**KIRKLEES METROPOLITAN COUNCIL
INVESTMENT & REGENERATION SERVICE**

**DELEGATED DECISION FOR APPLICATION FOR CERTIFICATE OF
LAWFUL DEVELOPMENT**

Reference no.: 2025/CL/91489/W

Site: 402, Bradley Road, Bradley, Huddersfield, HD2
1PS

Proposed Attic Floor Plan
1:50

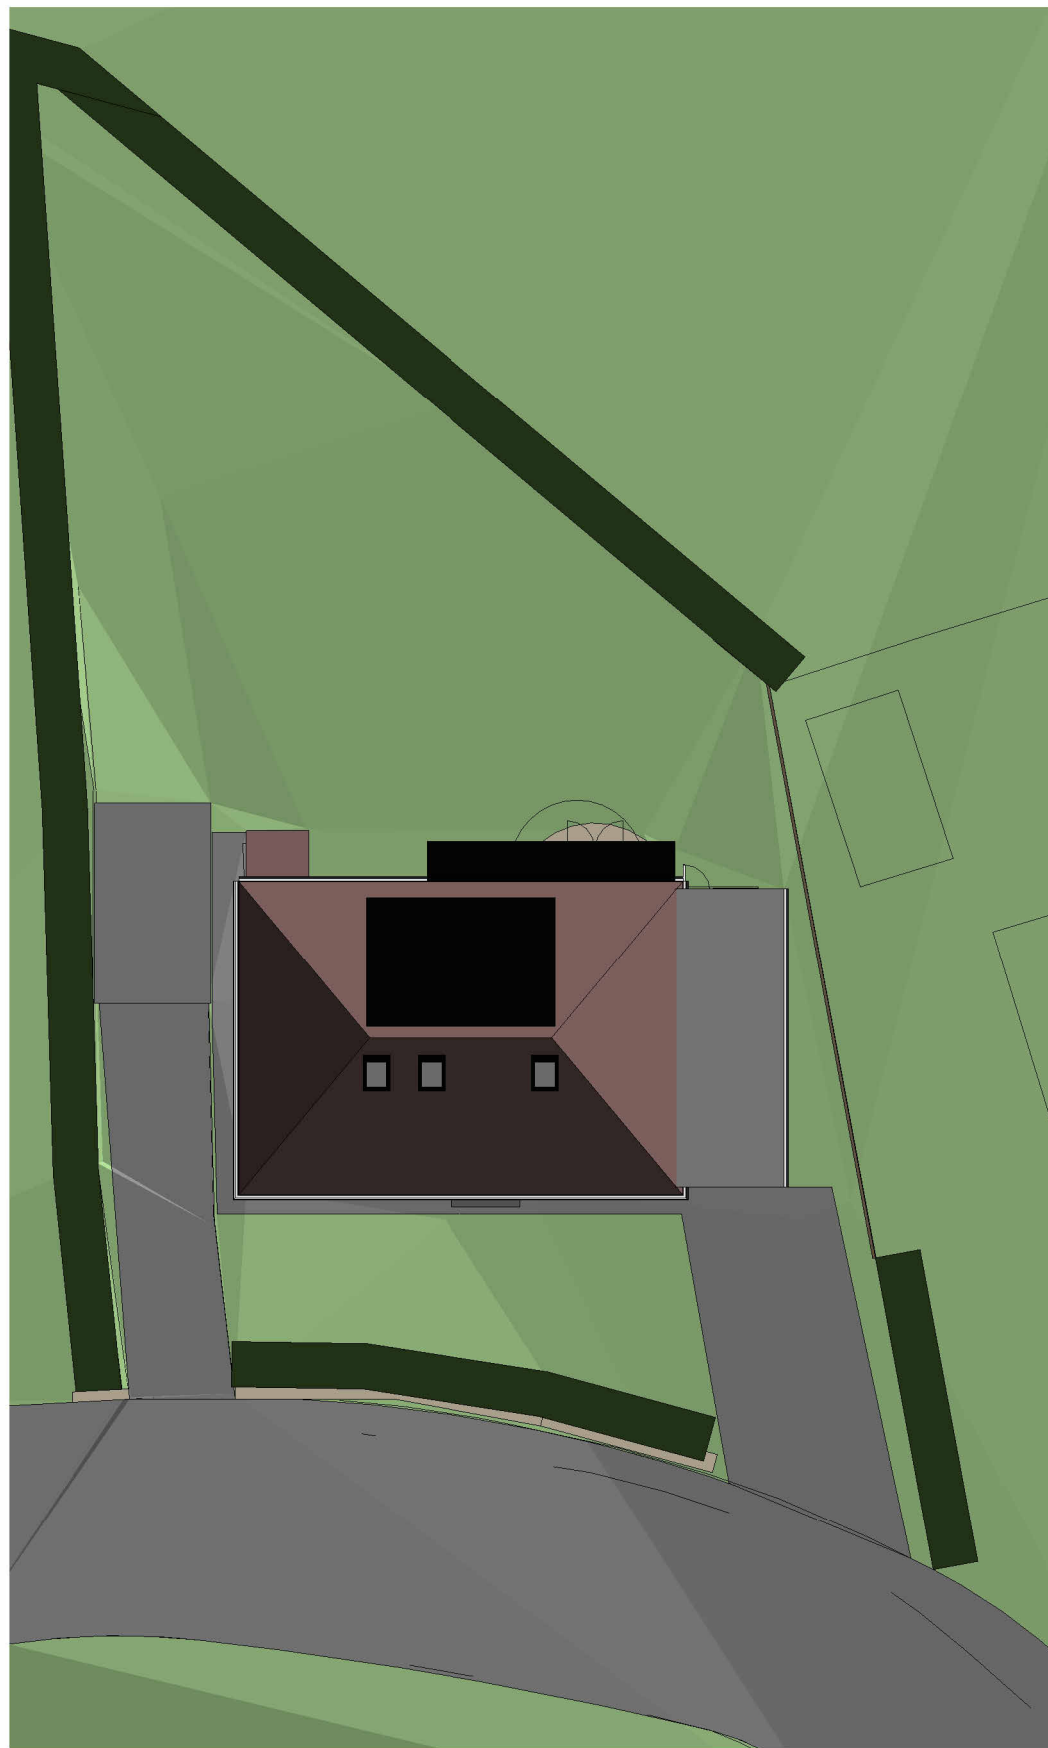
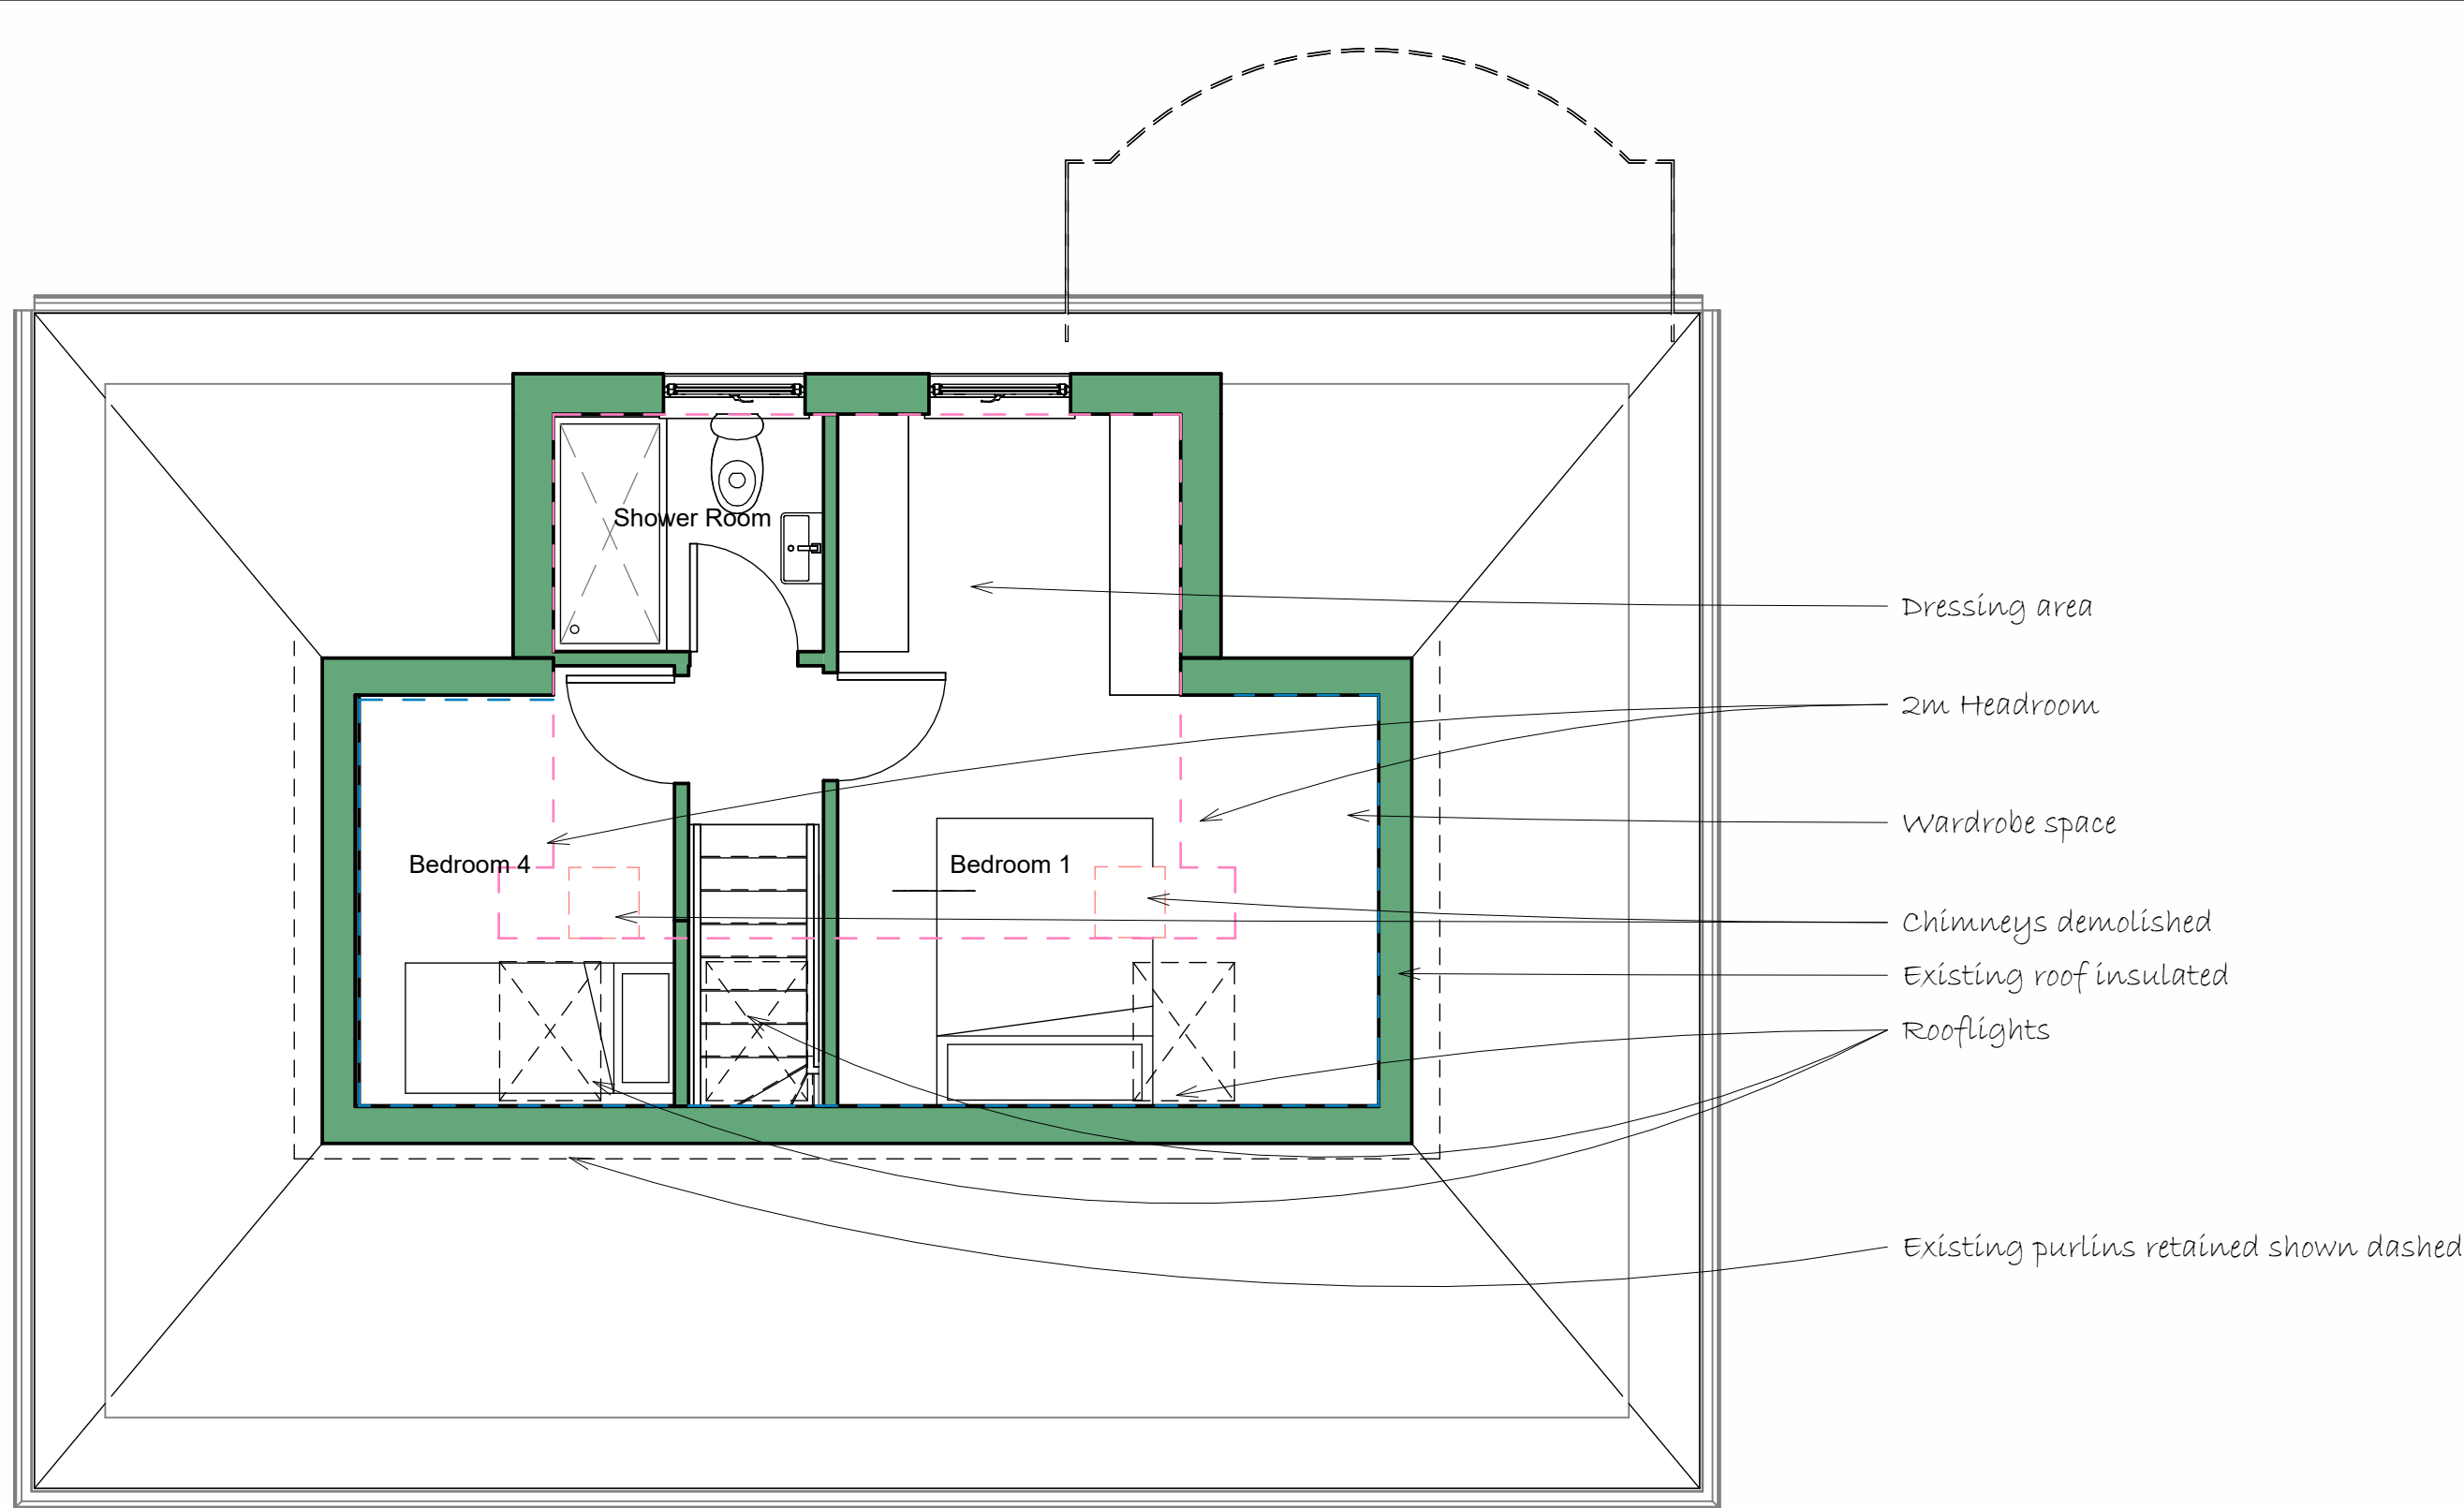
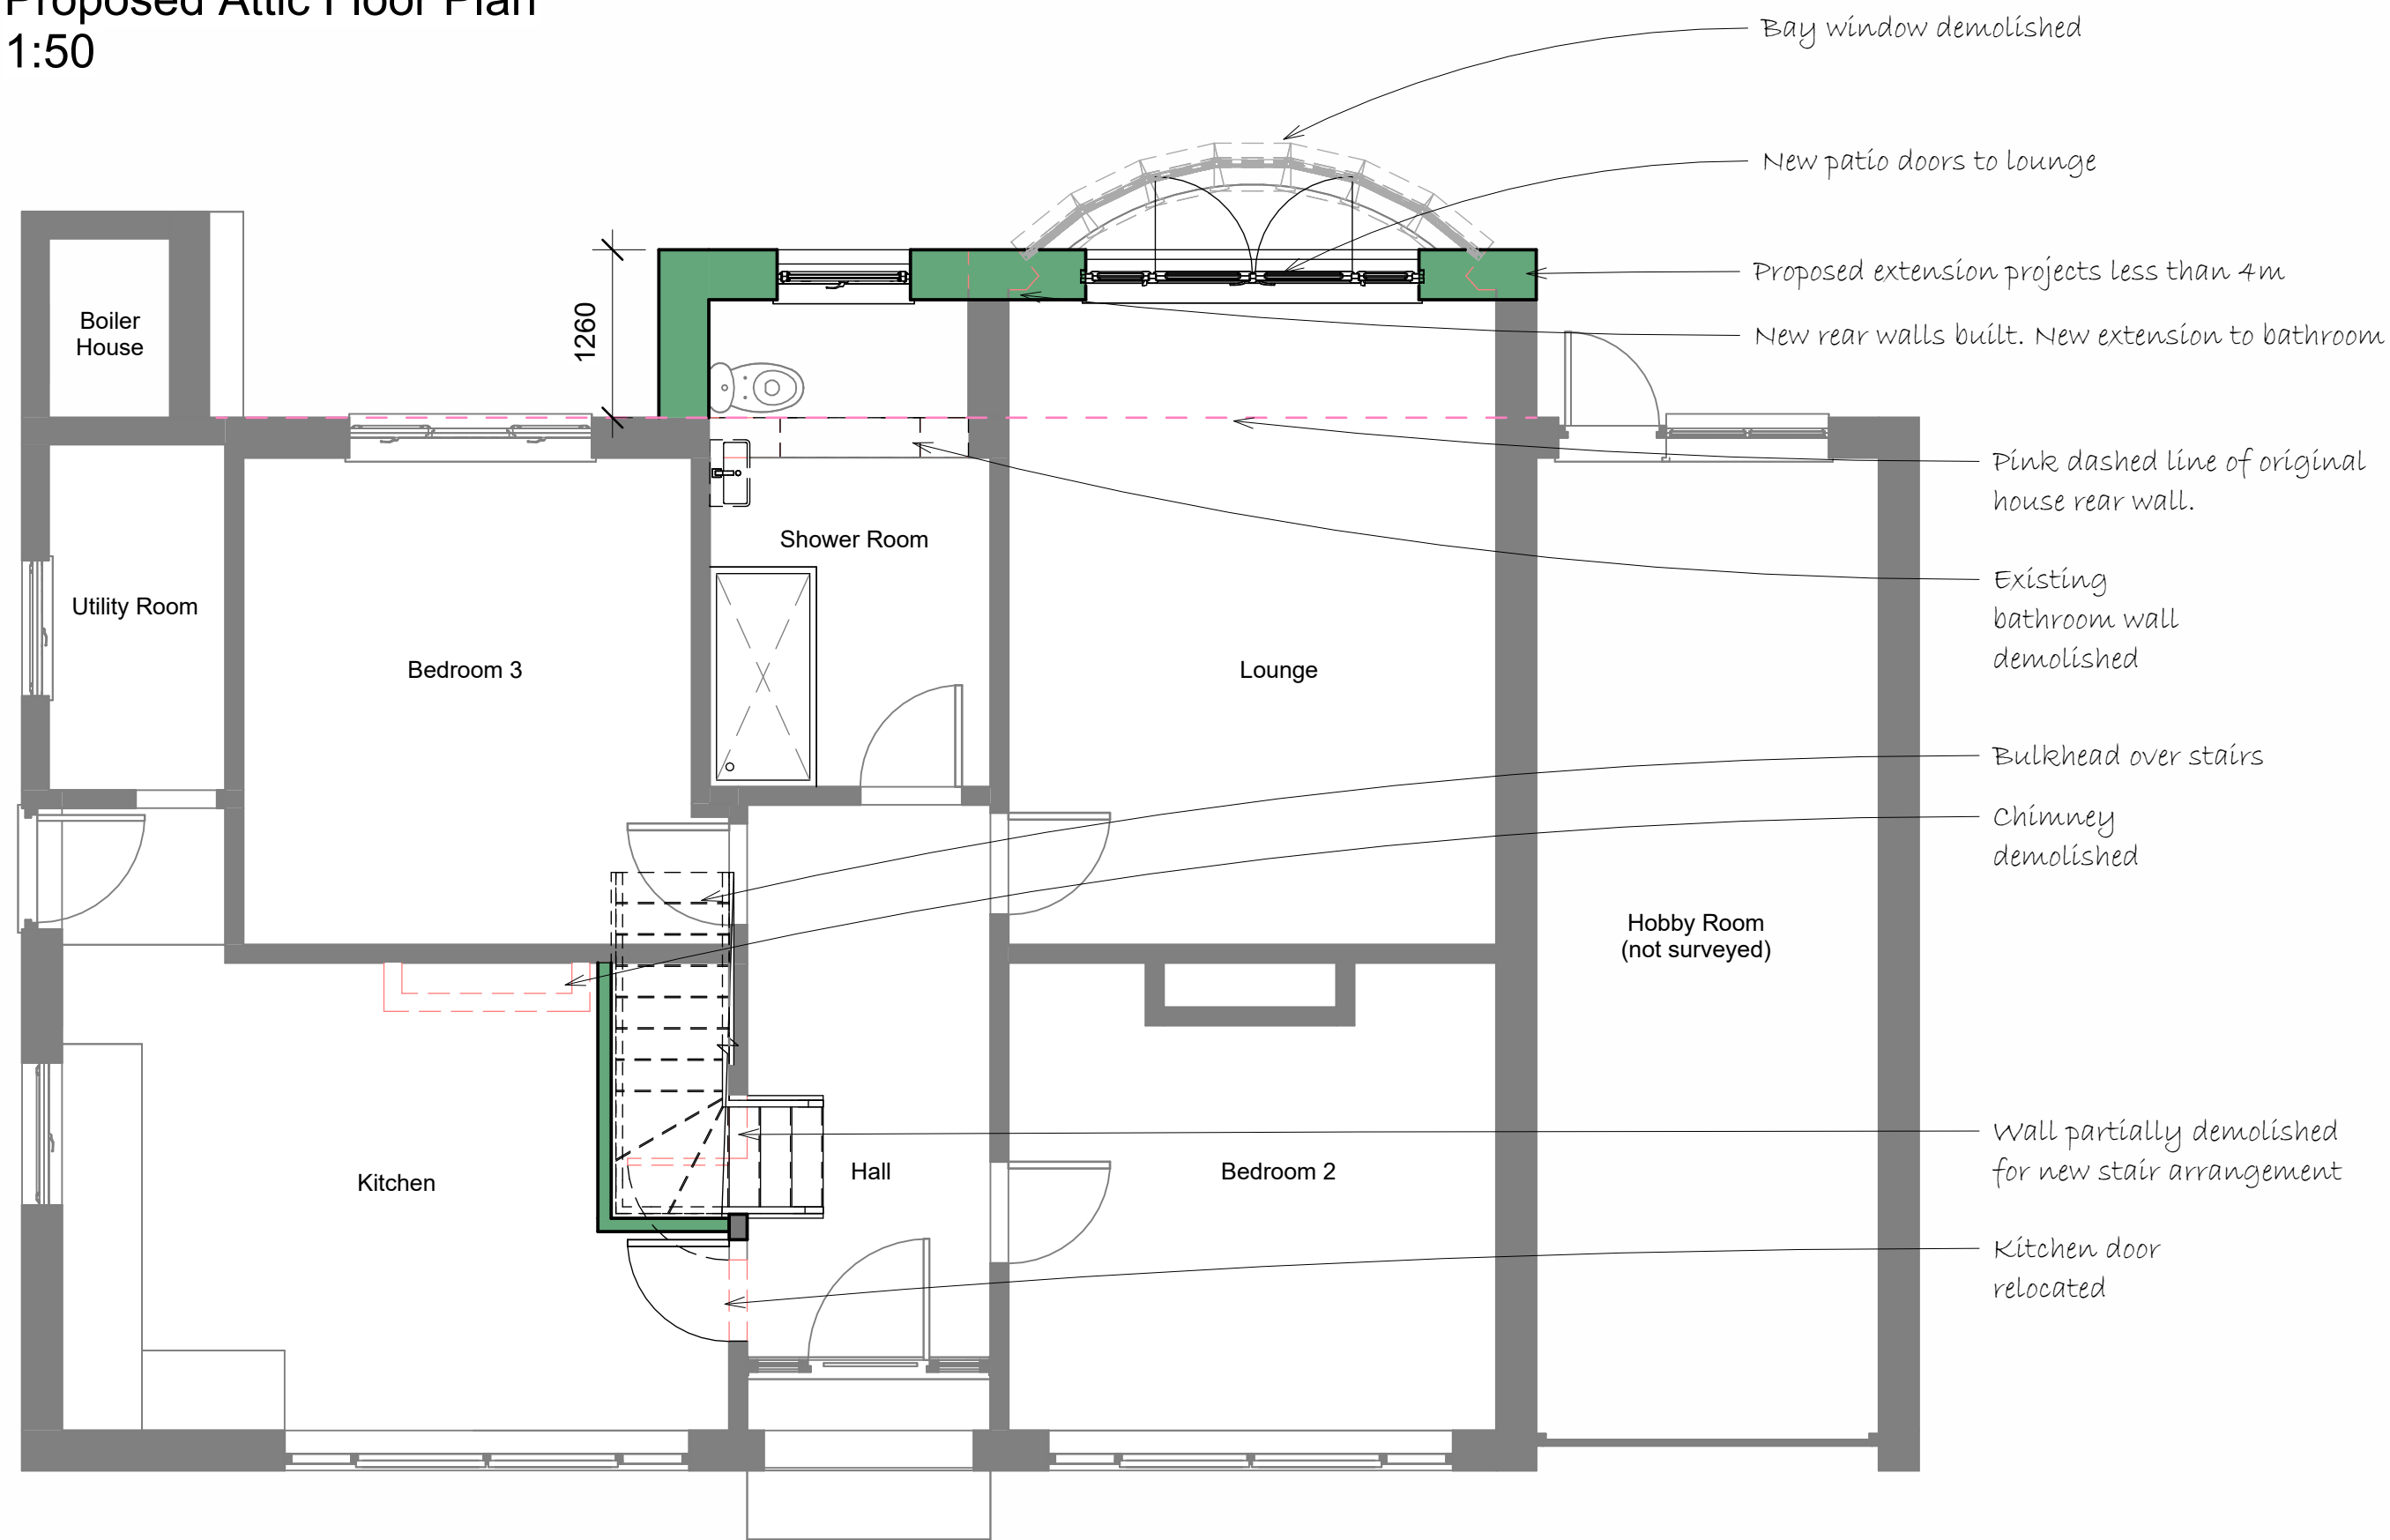
Comment: *The existing plans demonstrate that 2 no. chimneys are located on the ridge of the existing roof form. The proposed attic floor plan (drawing number 2025126-102) clearly annotate that the chimneys would be demolished and therefore an alteration to a chimney. This would constitute an alteration of a chimney and therefore would fall within Part 1, Class G of the Act (as amended) and shall be assessed as part of this report.*

Comment: *The existing plans demonstrate that 2 no. chimneys are located on the ridge of the existing roof form. The proposed attic floor plan (drawing number 2025126-102) clearly annotate that the chimneys would be demolished*

and therefore an alteration to a chimney. This would constitute an alteration of a chimney and therefore would fall within Part 1, Class G of the Act (as amended) and shall be assessed as part of this report.
